Application No: A/24/21/PL
Site Address: Land South of Water Lane Angmering
Description of works: Erection of a temporary sales cabin with 4 parking spaces and associated landscaping. CIL Zone 1 - This application is zero rated as temporary building.

Thank you for your internet representation made on 16th March 2021 which has been recorded as an objection with the comments as follows:

I am writing to register my objections to the proposed planning application A/24/21/PL. My Grade II property is directly opposite the proposed entrance to the sales cabin.

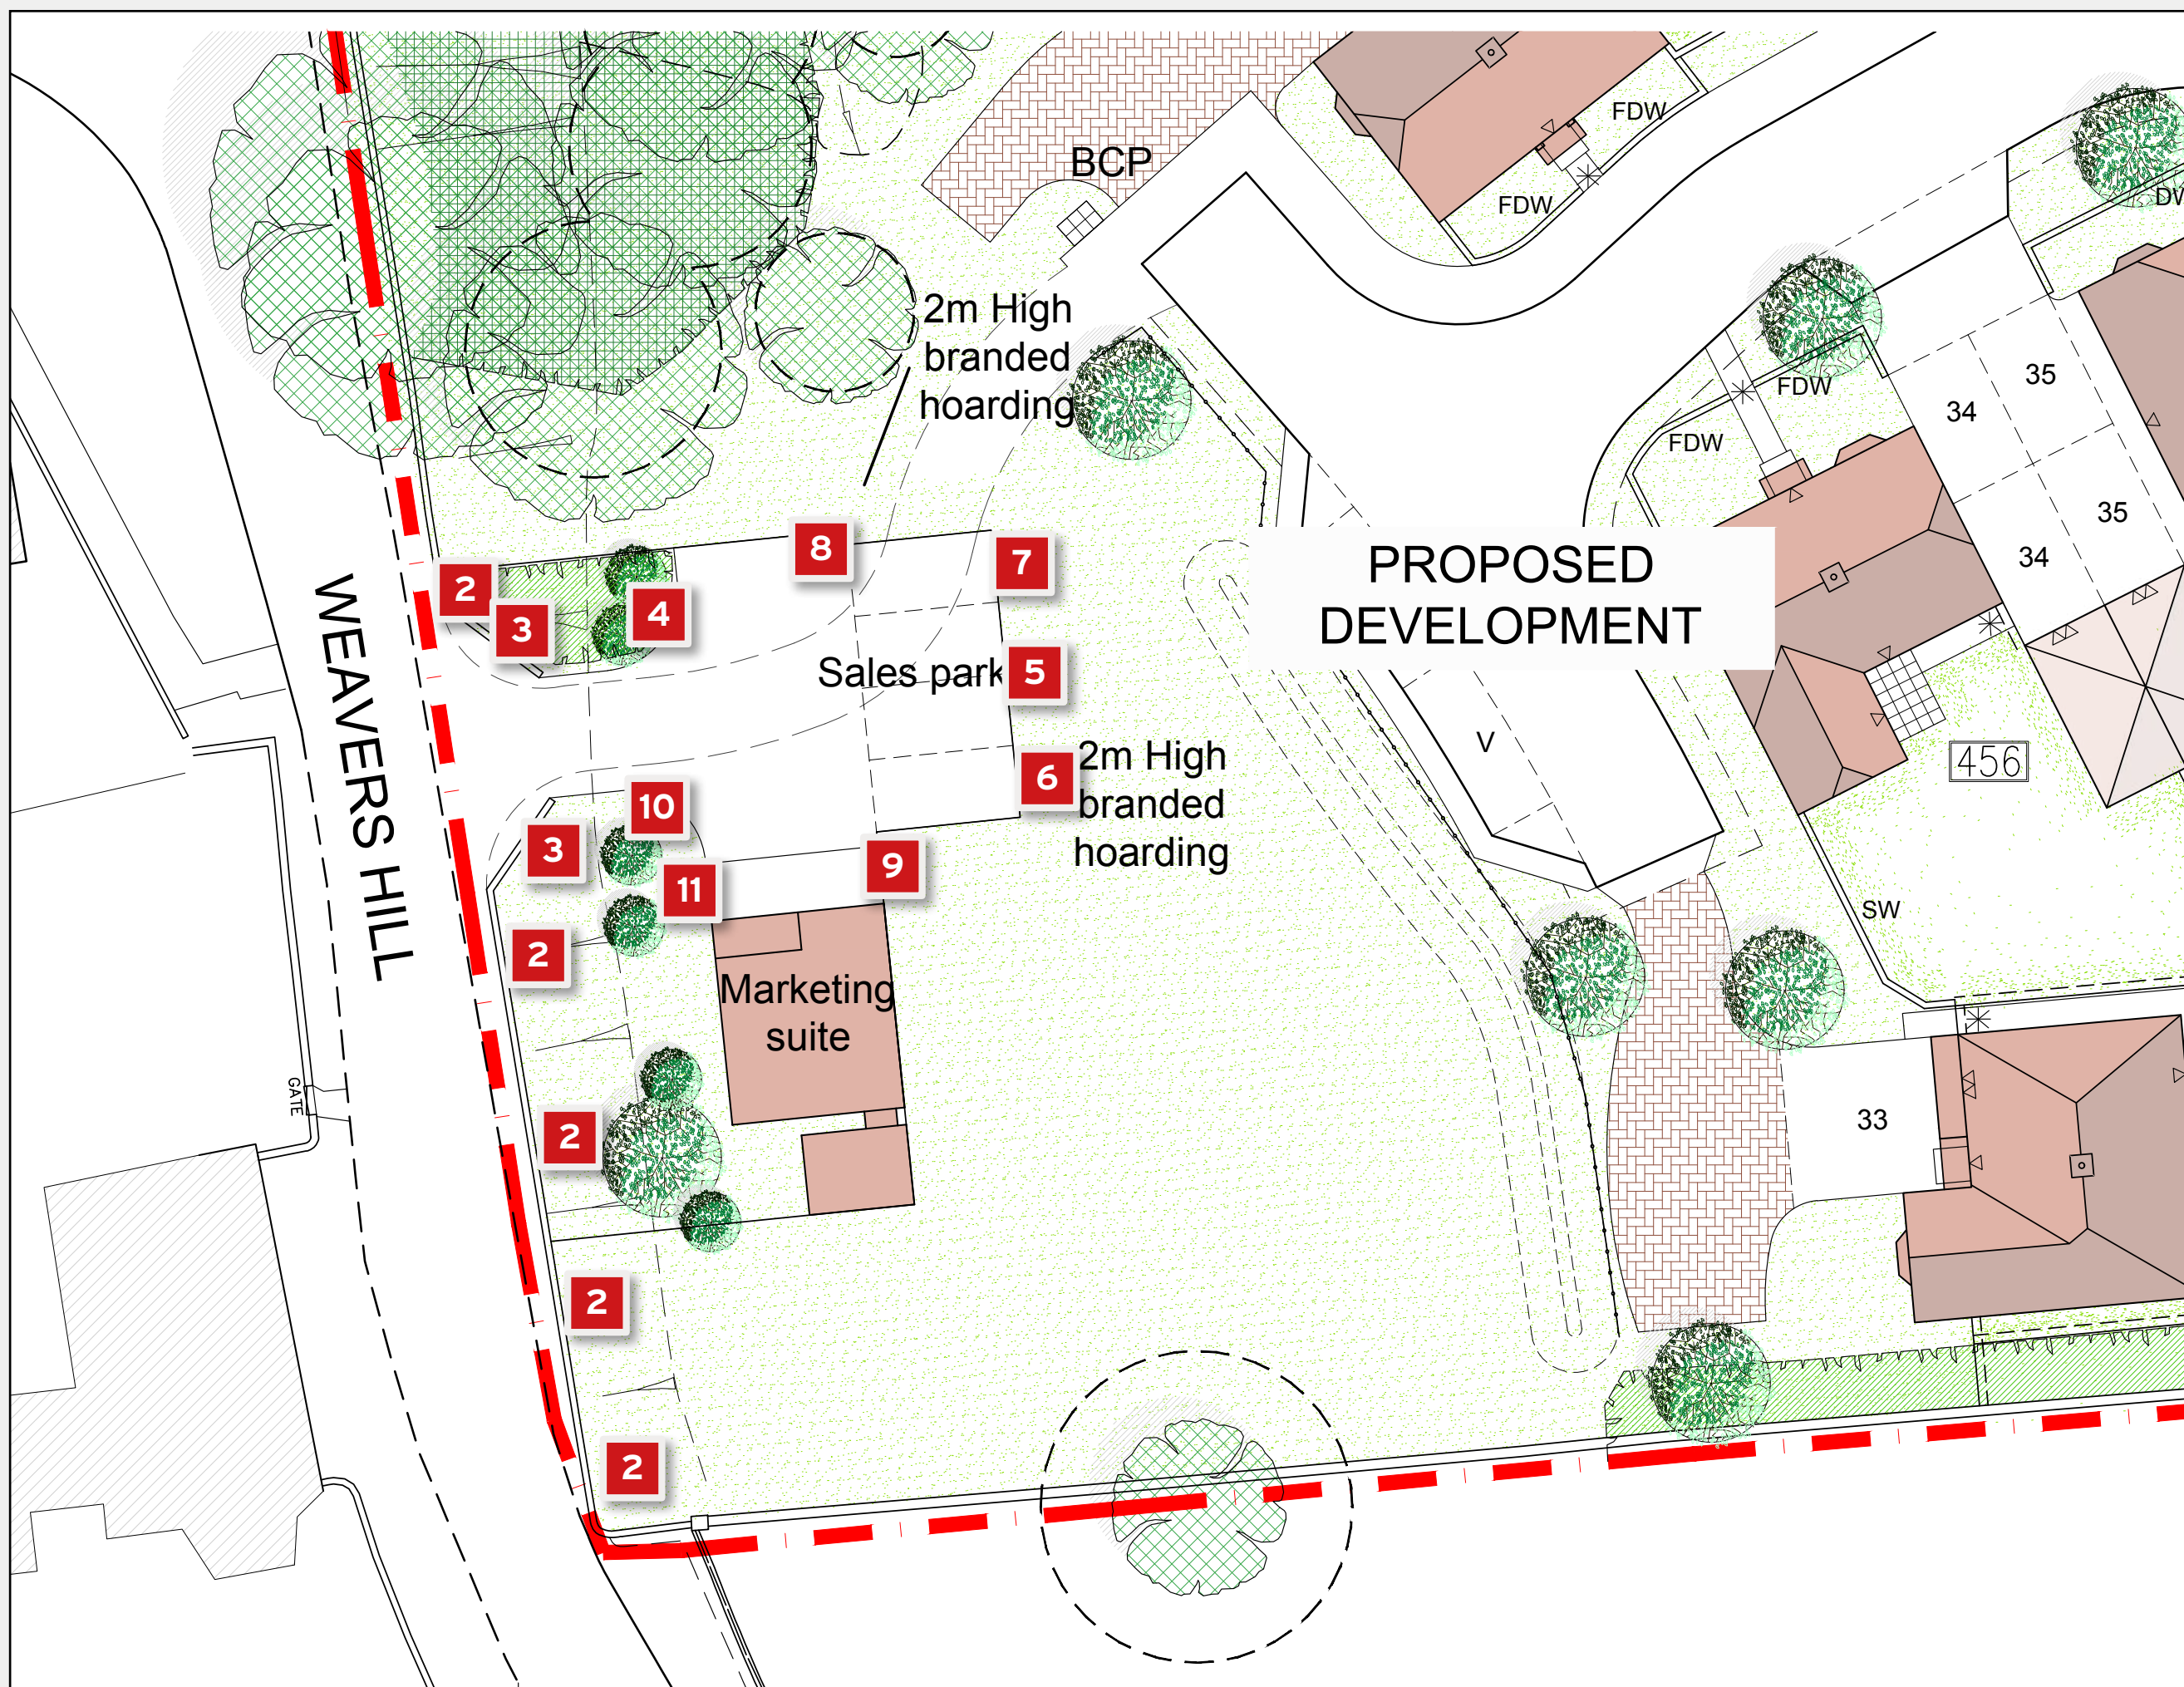
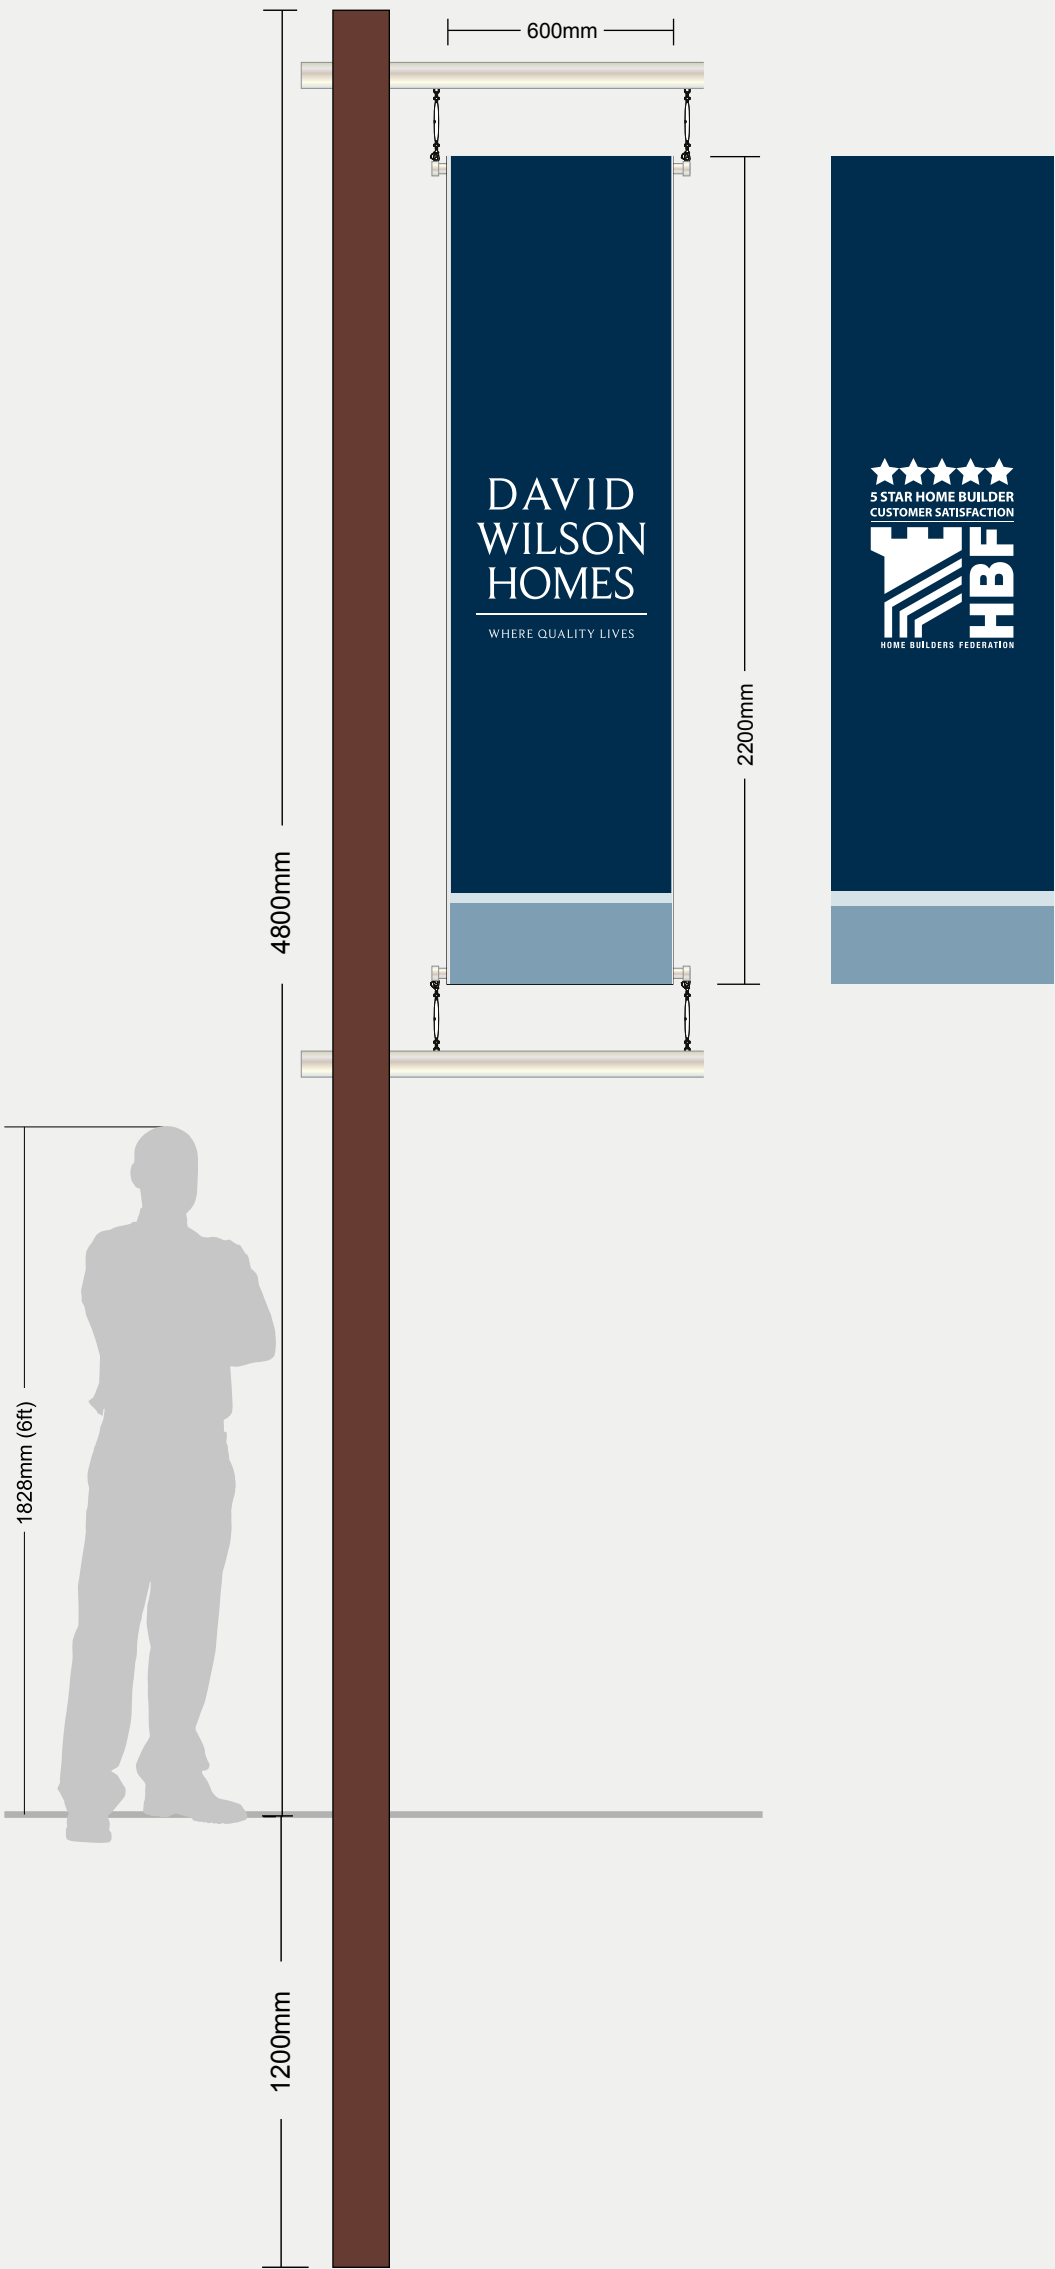
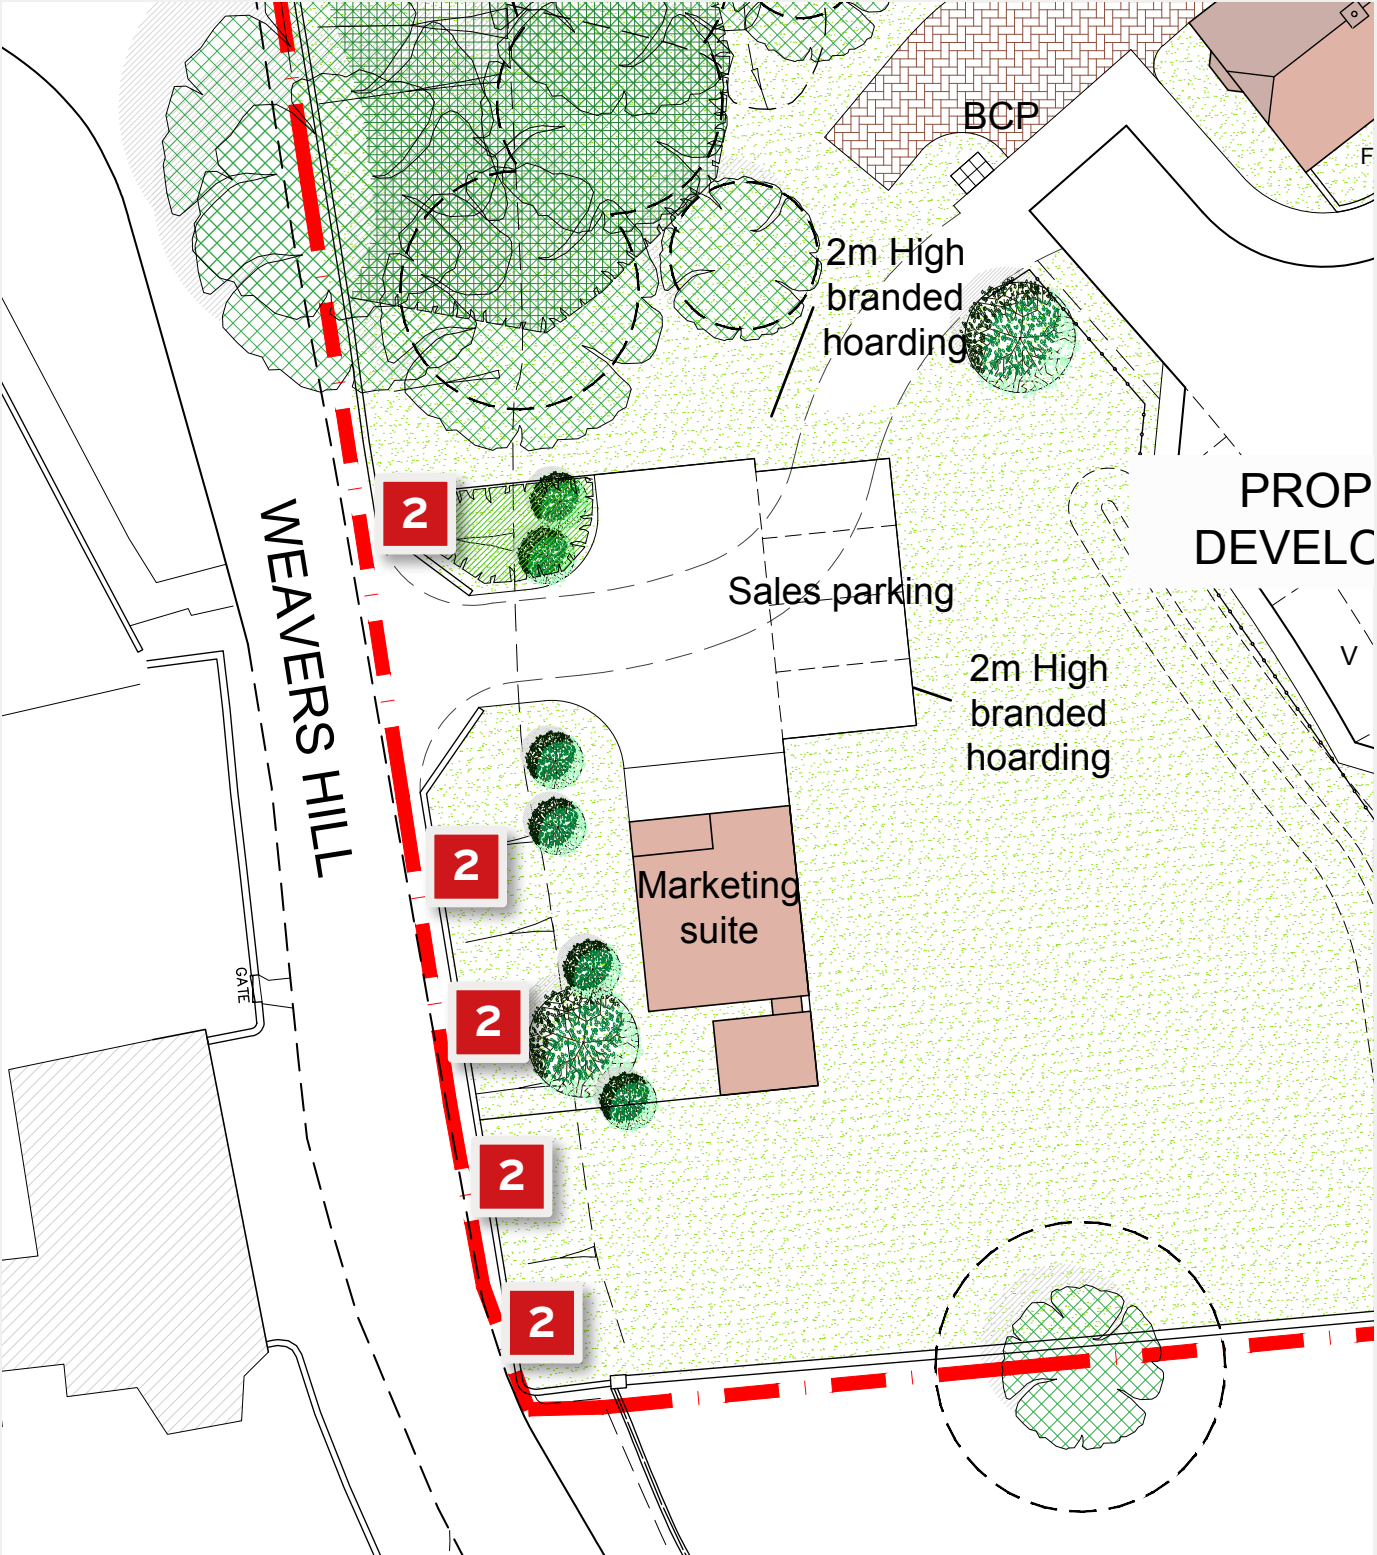
The erection of 10 advertising totem signs and 5 advertising flags, prominent commercial structures designed

to attract attention from a distance, will be totally out of place and will have a detrimental effect for multiple years on the character of the Angmering Conservation Area. The flags and the associated rope will generate noise in the wind and cause disturbance to the residential properties close to the site for multiple years.
